In reply please quote: 09/03134
Your Ref: SSD 6078 MOD 3

**SSD 6078 MOD 3 - PROPOSED MODIFICATION TO OAKDALE CENTRAL –
WAREHOUSE 2B - EXHIBITION OF ENVIRONMENTAL ASSESSMENT**

The following comments are provided on the proposed modification (MOD 3) that applies specifically to warehouse 2B within the Oakdale Central Estate, Horsley Park. The proponent's Statement of Environmental Effects states the S.96(1A) modification remains substantially the same as the approved scheme, with the proposed modifications enhancing certain aspects of the design to reflect requirements of proposed tenants of the site.

Figure 4: Proposed layout of Unit 2B for proposed DHL Facility

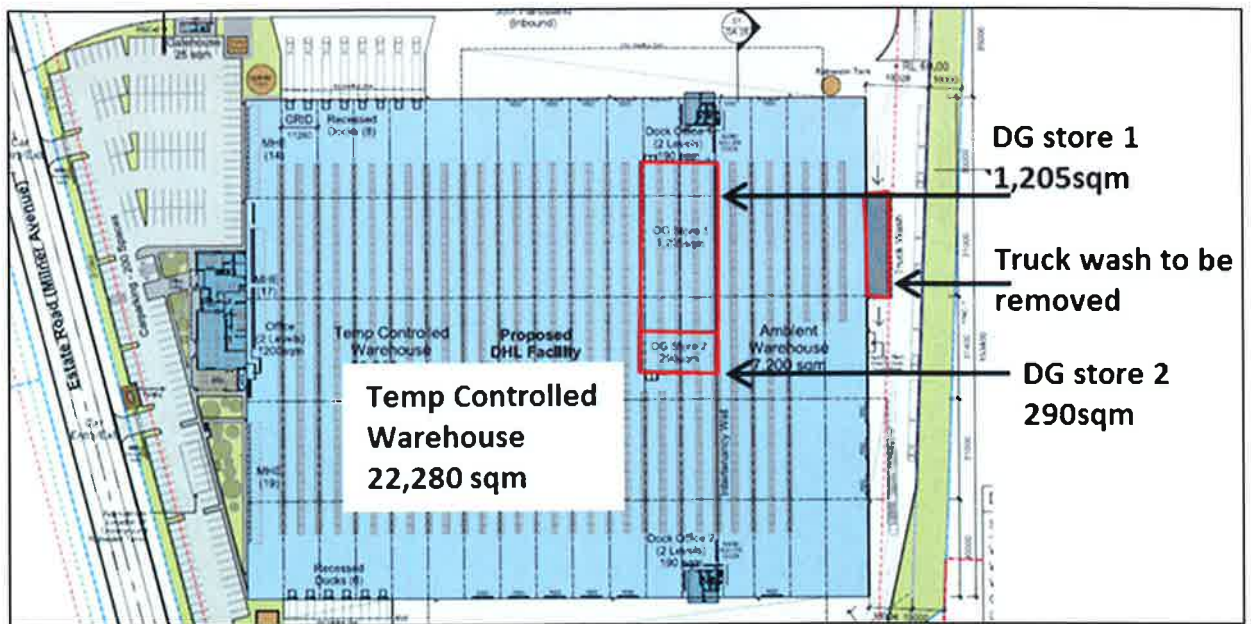
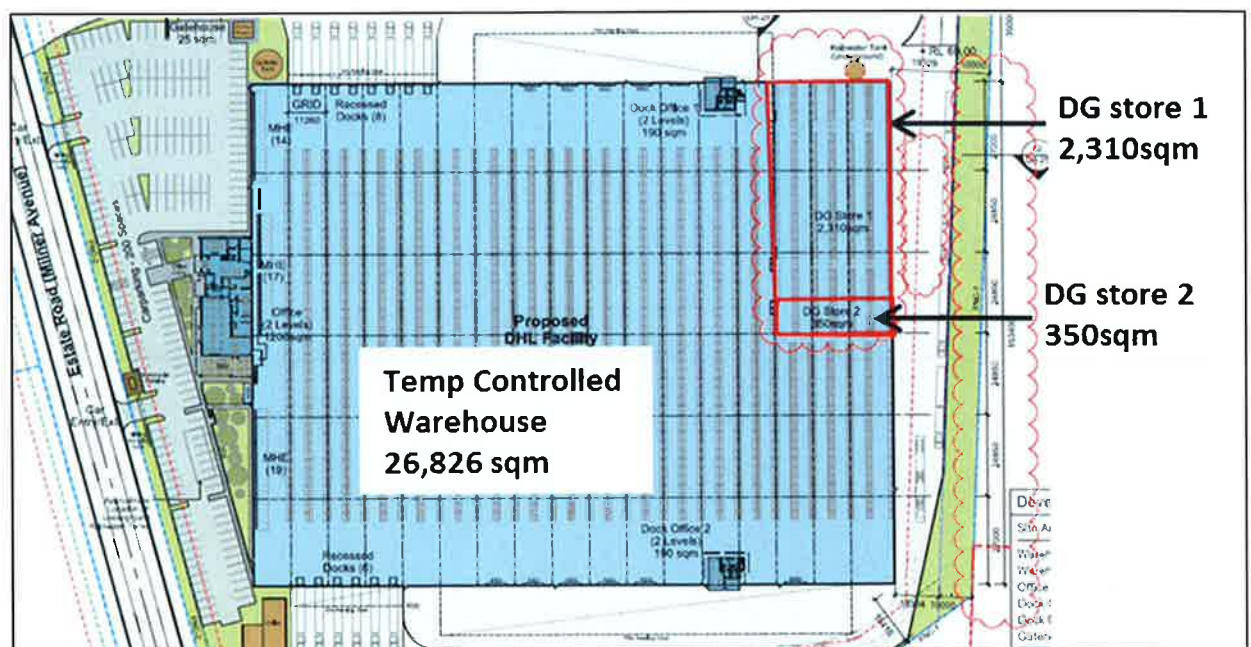
The SEE shows the entire warehouse converted to refrigerated storage. No details are provided regarding any further refrigeration machinery to be installed to service this expanded area, or any increased noise generated from this. As stated in previous Council's previous comments dated 21 May 2015, an operational acoustic report should be prepared to confirm that final operational conditions are acceptable.
